PORTLAND MAINE

February 26, 2008

RE: 49 Ryefield Street
CBL: 085-F-005001

This is a **SUSPENSION ORDER** pursuant to Section 105.6(Suspension or Revocation) of the International 2003 Building Code. Permit # 07-1336 is suspended until an amended permit application is submitted showing compliance with current Zoning requirements or a variance request is approved by the Zoning Board of Appeals. This is a **STOP WORK ORDER** pursuant to Section 114.1 (Authority) all construction activity at the above referenced property must **STOP** immediately.

Site Plan Sketch

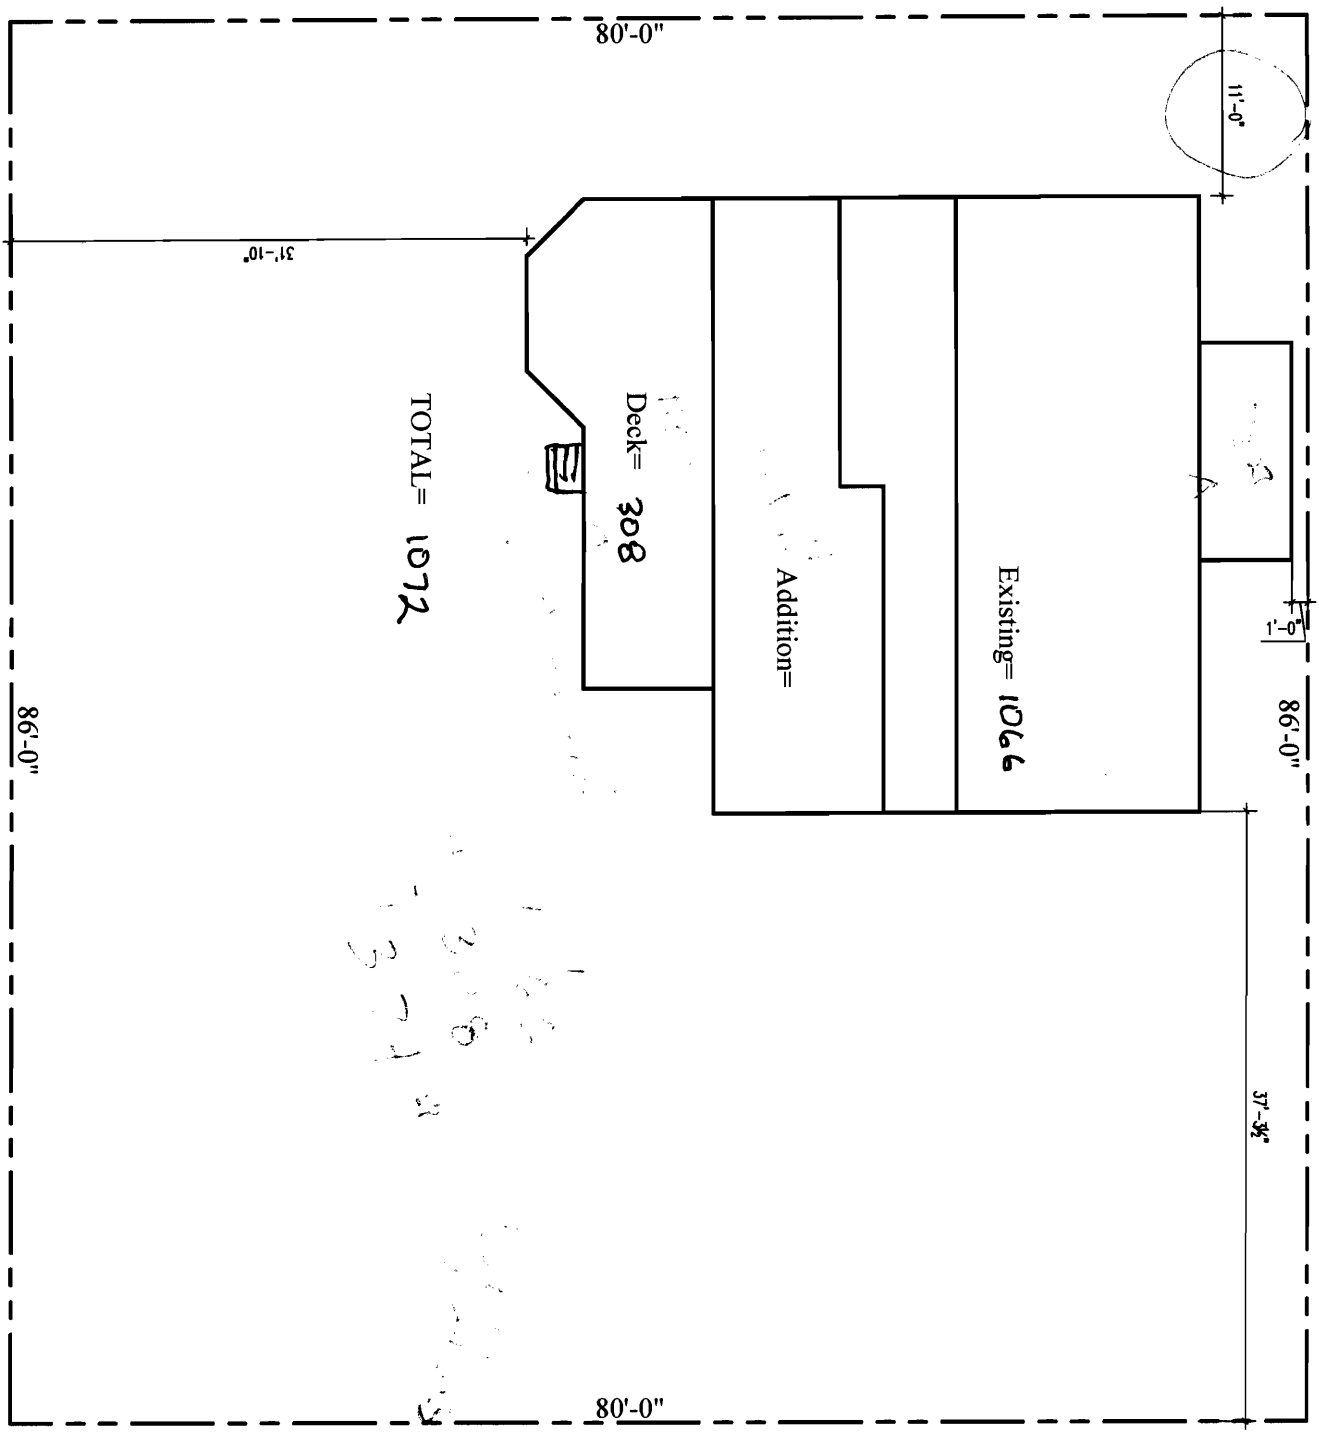
An evaluation of the permit for 49 Ryefield Street revealed that the application fails to comply with Section 14-145.11 of Chapter 14 of the Land Use Ordinance of the City of Portland. Lot coverage of the planned addition show it exceeding the 20% allowed for total lot coverage. Setback requirements for the IR2 Zone are 20ft on the sides and 25ft in the rear. Your submitted application shows 10ft on the left side 11ft in the rear.
